**SITE 43/44, SYDNEY OLYMPIC PARK
 DESIGN EXCELLENCE COMPETITION
 JURY REPORT – 23/08/10**

Executive Summary

6 JUN 21 - 3 PM  
1 : 1000

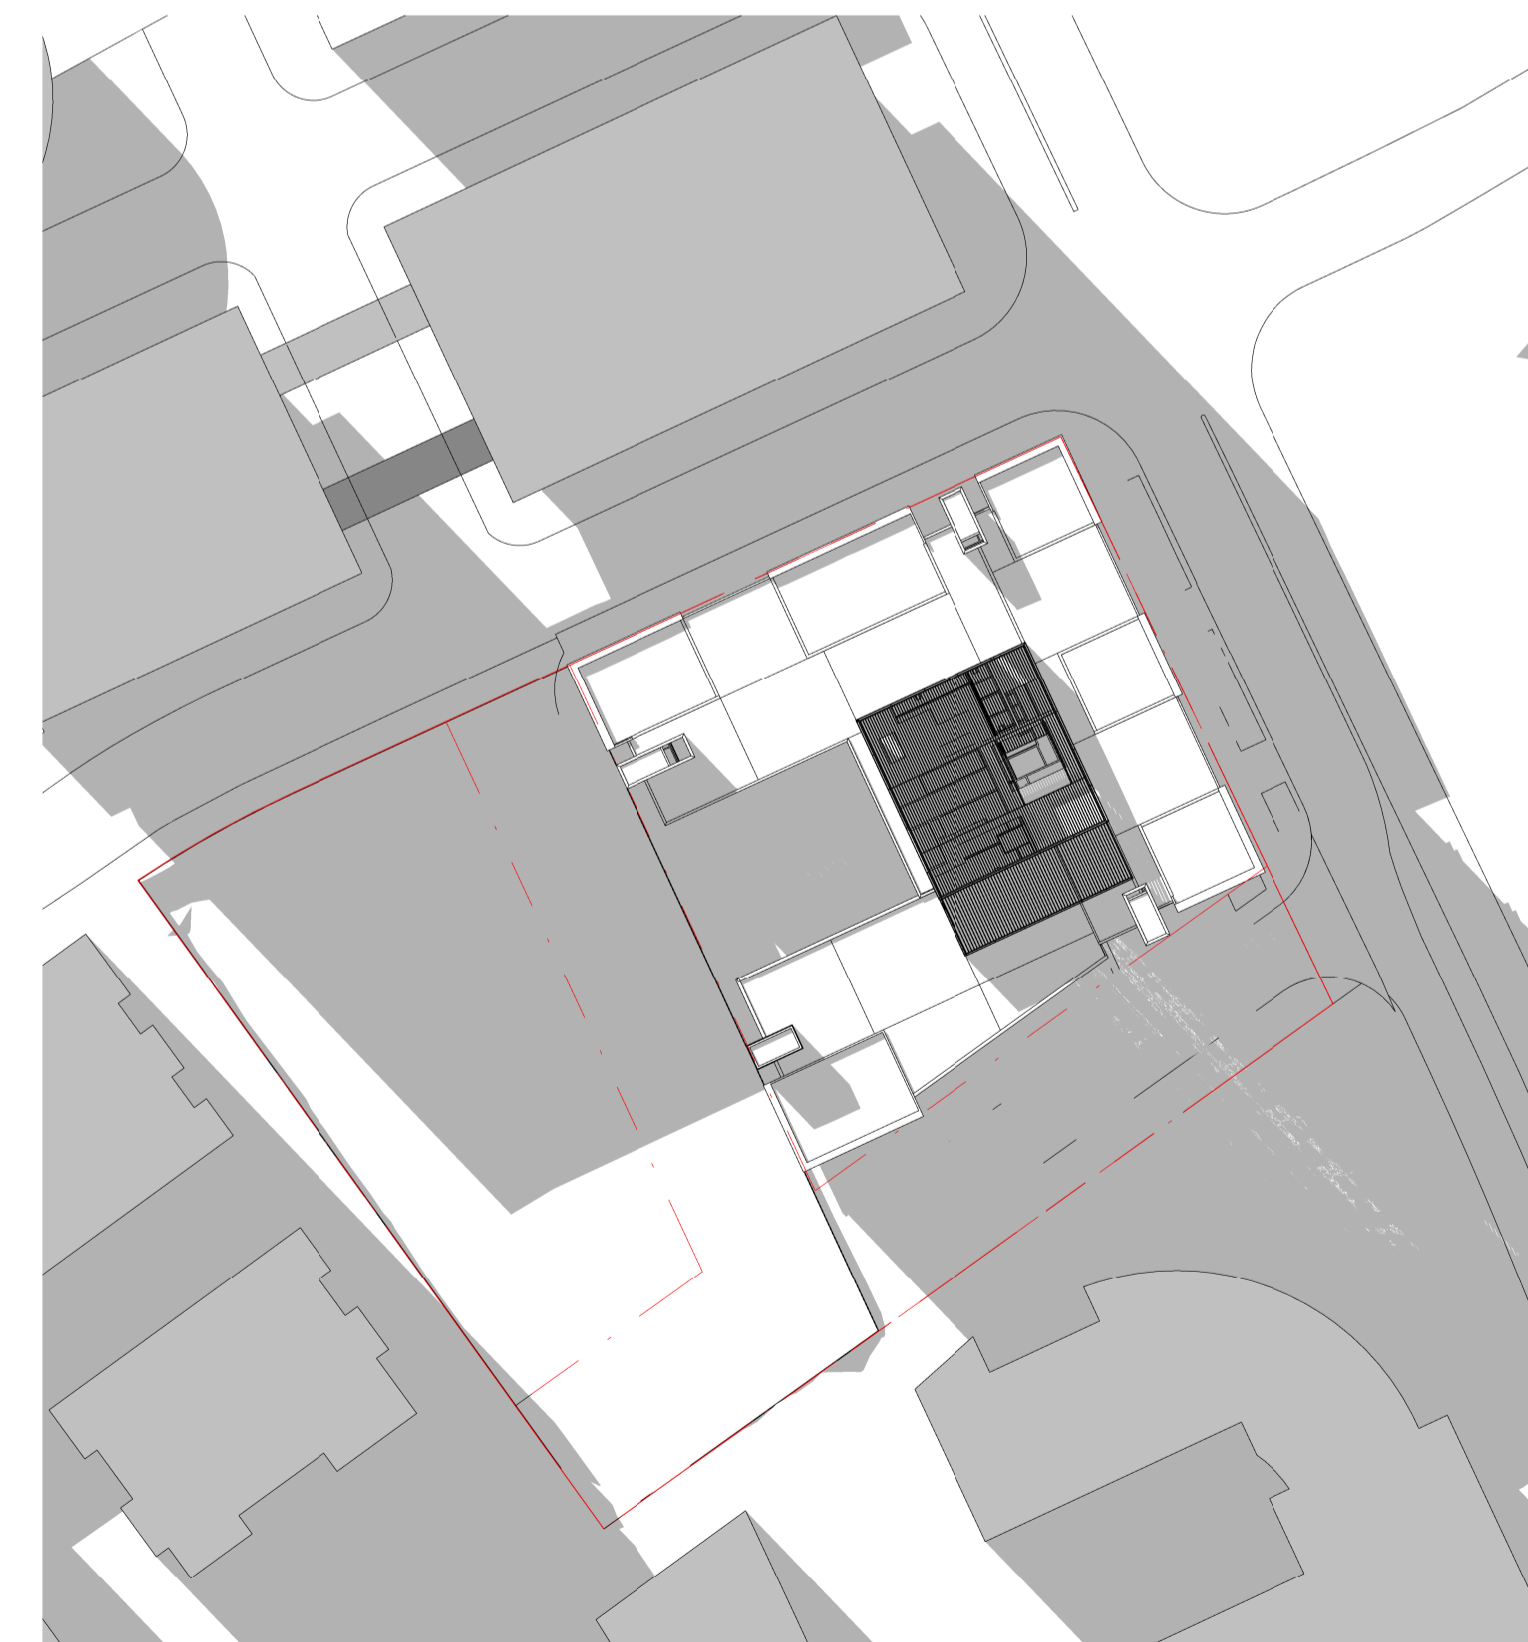
- The proposed loading zone for the supermarket noting that the cost and area occupied. This requires further consideration.
- Overshadowing of the courtyard will also need to be reviewed due to the orientation of the surrounding buildings.
